M54 to M6 Link Road

PI Ref TR010054

Written Representation by Allow Ltd - Deadline 1 – 3rd November 2020

Plot Date: 20 January 2020 11:42:07
File Name: L:\PROJECTS\M05018038\M54-M6 LINKS\0 - TECHNICAL\8 - DIVISION\ENVIRONMENTAL MITIGATION\FIGURE 2.6 DRAFT ENVIRONMENTAL MASTERPLAN P10

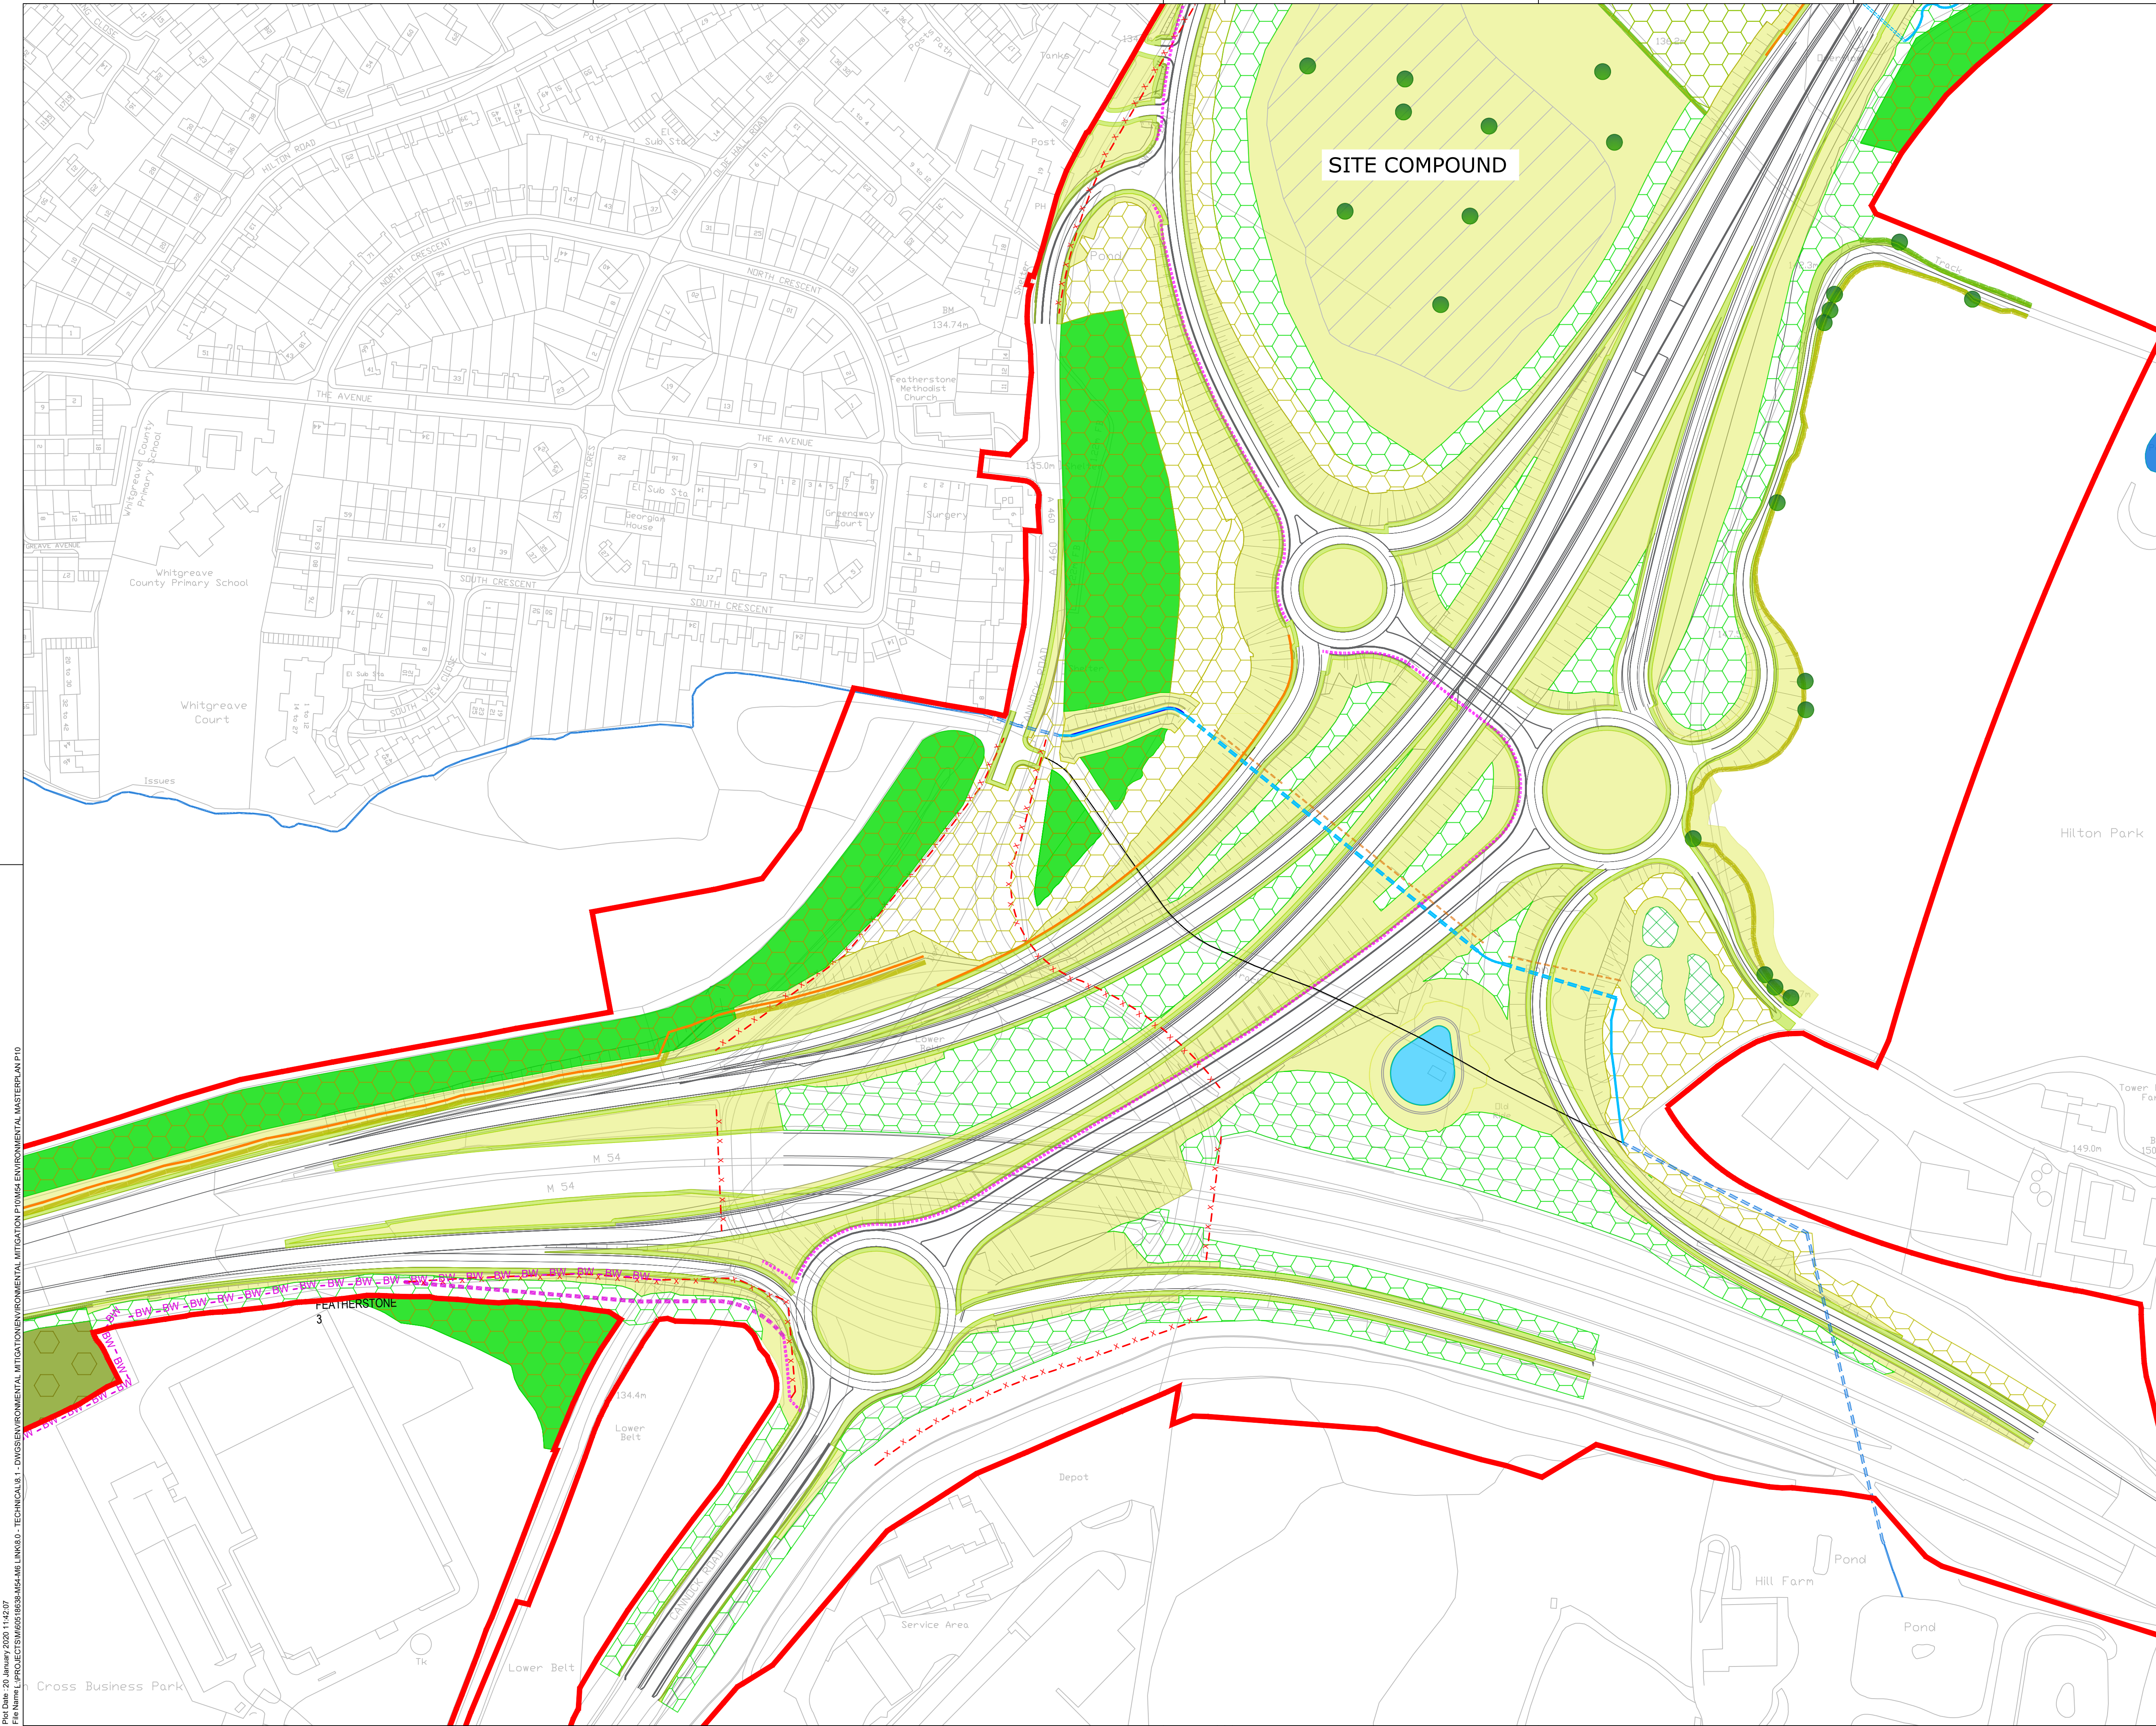
- 4.4 The original area of land proposed to be lost within the SBI referred to in the Environmental Statement was of 1.83 ha of woodland and 0.55 ha of standing water. The revised Environmental masterplan plans (21.08.20) show a larger area than originally proposed to be felled, despite a contradiction in the accompanying rationale document which states that there would be a reduction in the impact on the Lower Pool SBI of 1 ha. The revised ES submitted on 16th October provides updated areas of 2.04 ha of woodland and 0.46 ha of standing water to be lost from the SBI.

- 4.5 There has been a lack of explanation and narrative around the scheme changes, which when combined with the contradictory information on the rationale document, which formed part of the consultation, compared to the revised Environmental Masterplans, and those environmental masterplans also showing inaccurate information as to revised public rights of way alongside Dark Lane, has led to inaccuracies as to what areas are necessary to be acquired to mitigate the impact of the Scheme. Allow object to the Applicants Acquisition of the Lower Pool SBI (Plot 5/4 and 4/20c) and request further clarity as to what area is proposed to be acquired for scheme construction and for mitigation of the scheme.

- 4.21 The large areas on woodland proposed on Allow Ltd's land (e.g. EW08) are located on the west of the proposed scheme. This will isolate planted woodland from other areas of woodland, plus Lower Pools SBI, in the landscape, reducing its effectiveness to contribute to existing ecological networks.

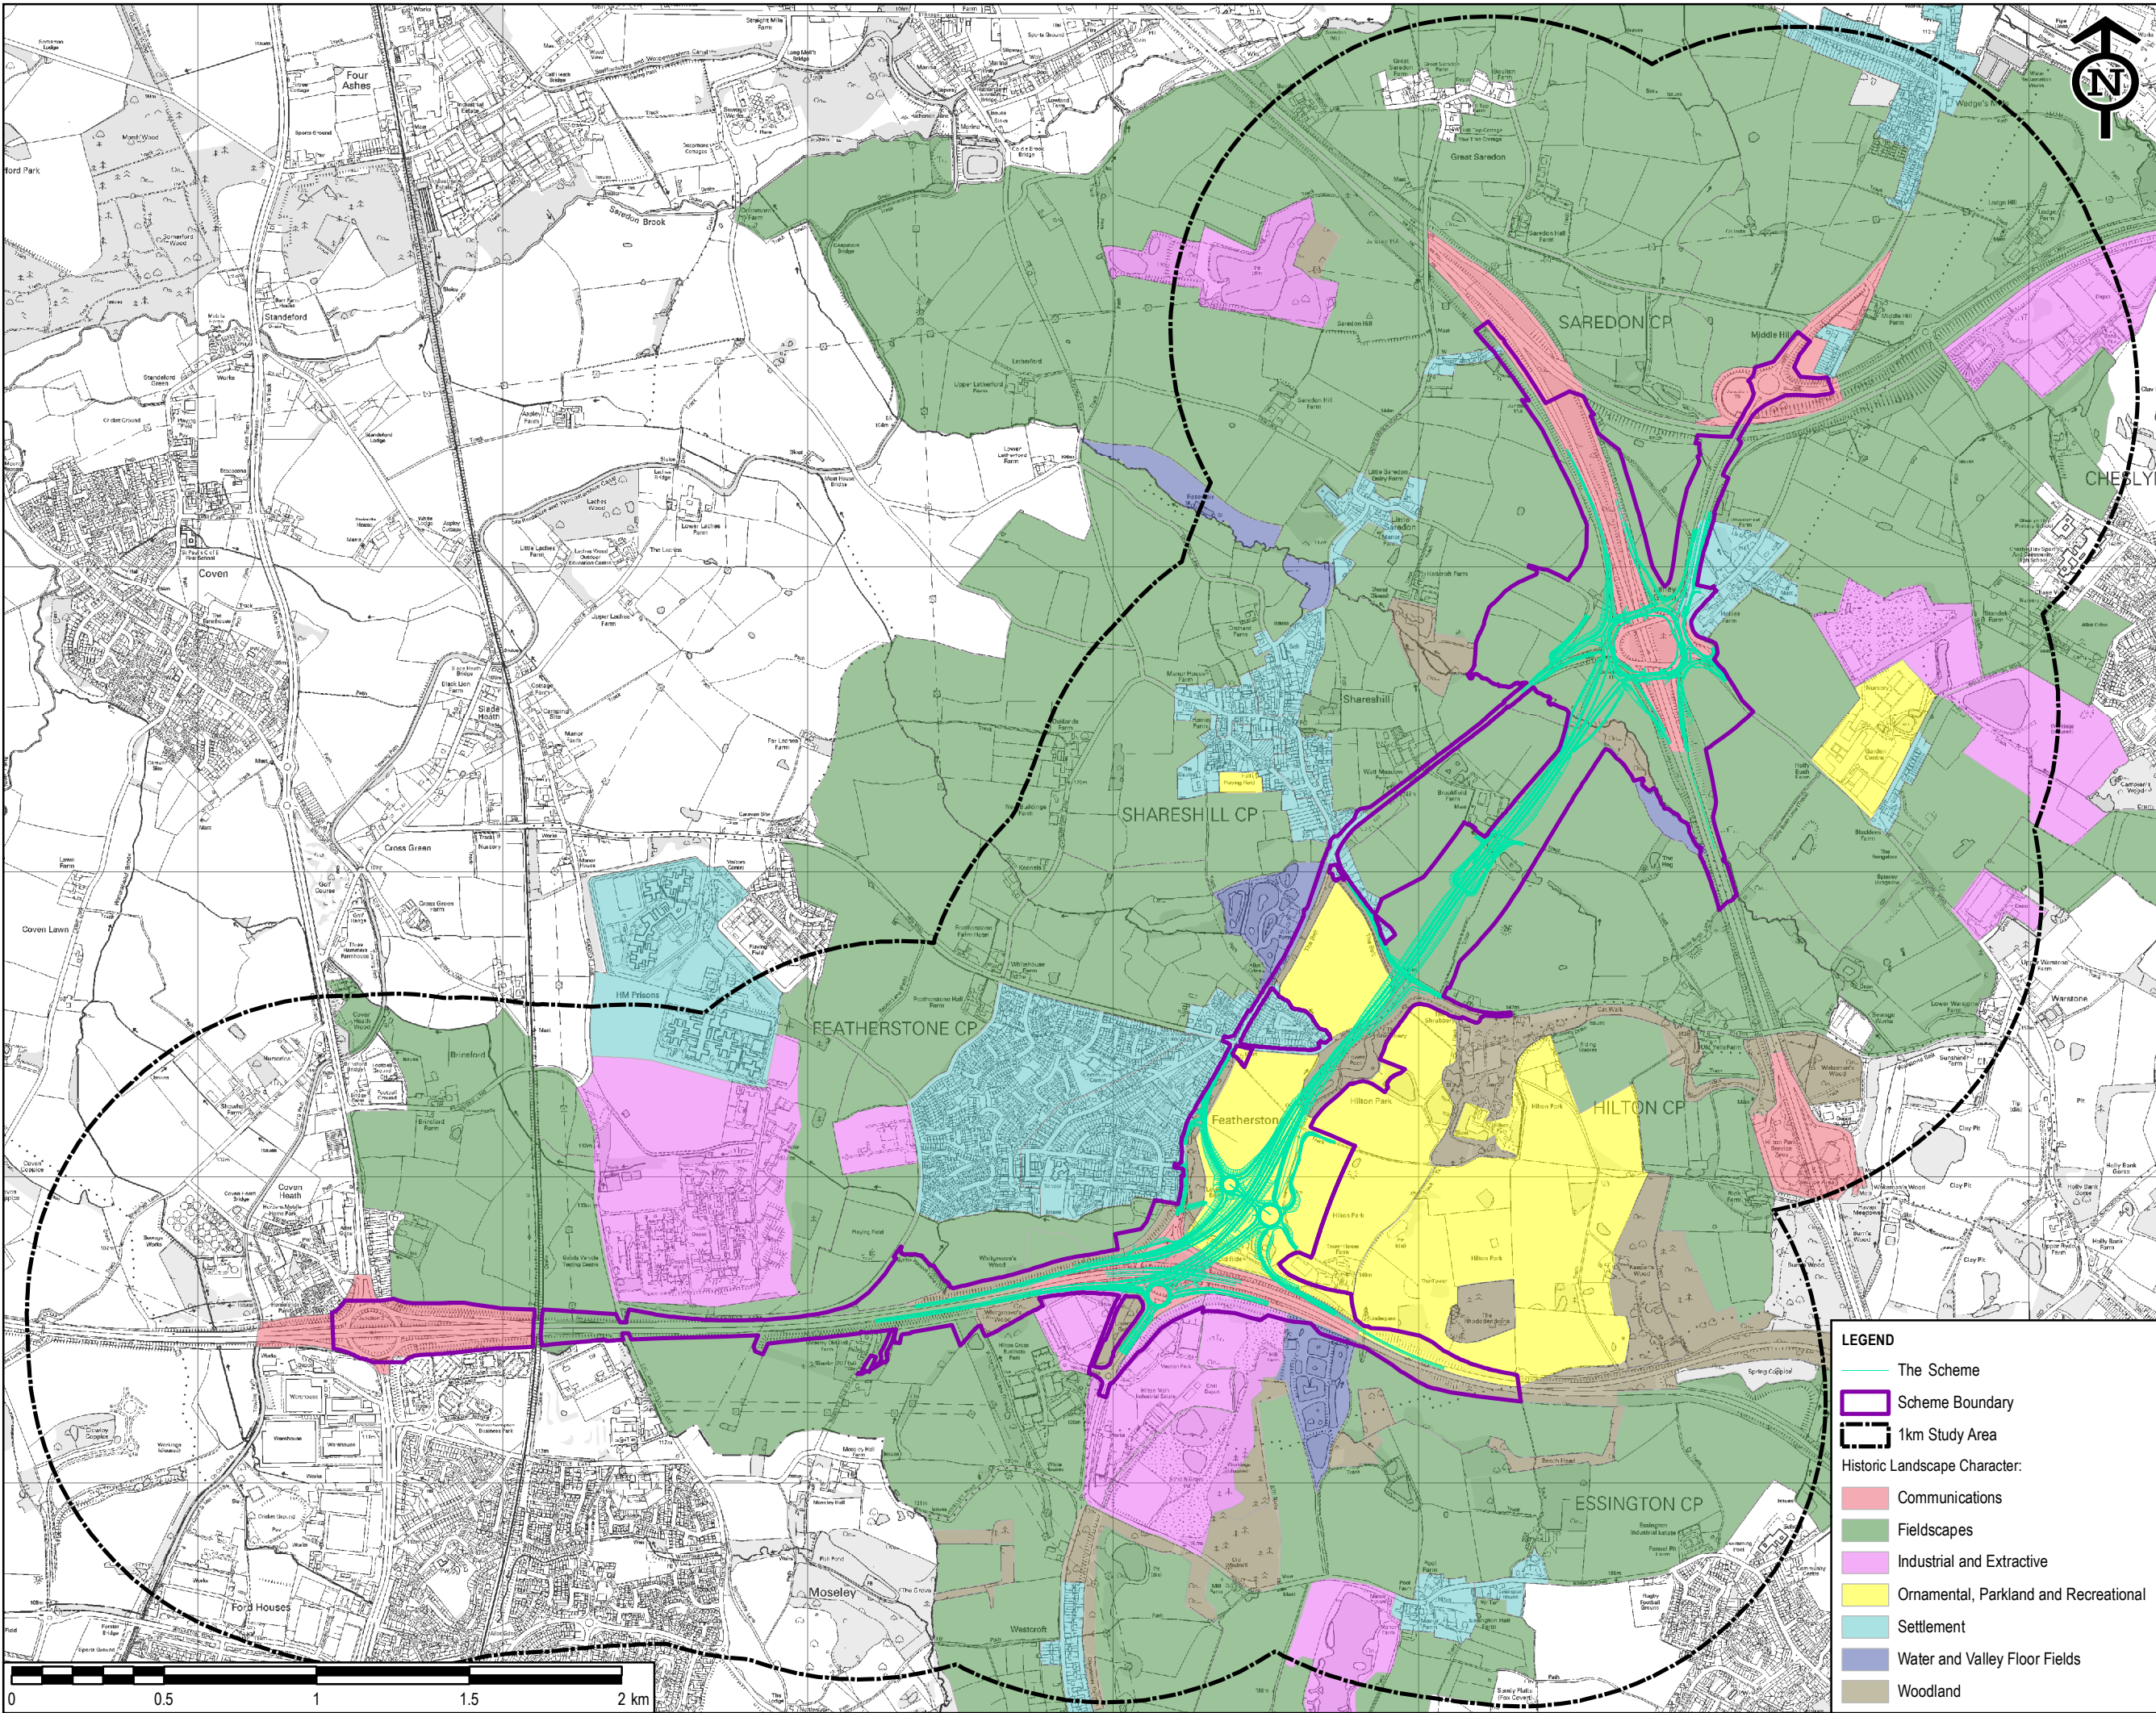
- 1.14 The Applicant has not correctly identified the historic landscape in respect of plots 5/2 and 4/20c and as such its approach to protecting the historic landscape is flawed. The Applicant has identified plot 5/4 and land to the east of plot 5/4 as being historic landscape when in fact all of Allow's Land Interests were part of the same historic landscape. Allow's Landscape Consultants, RPS ('RPS') have carried out its own assessment and identified that all of Allow's Land Interests

- 6.10 We consider that the level of importance of Hilton Park has been underplayed by the Applicant and that the correct value of the 'Conservation interests' factor in Table 7.7 of the ES should be 'Medium'. This would therefore mean that four of the seven assessed factors would be of 'Medium value' with the remaining three factors being of 'Low' value. The overall landscape value of the study area should therefore be considered to be 'Medium' rather than 'Low'.

- 6.11 The report states that the baseline description of the historic park presented in Appendix 6.5 of Chapter 6 of the ES is flawed. Also, the assessment fails to examine the impacts of the proposed environmental mitigation, which has an additional adverse impact on aspects of the historic landscape. The assessment in Chapter 6 of the ES focuses on the impact of the new road but even then fails to take into account the severance of the former principal access route to the house and the severance of Dark Lane which are both part of the designed landscape.
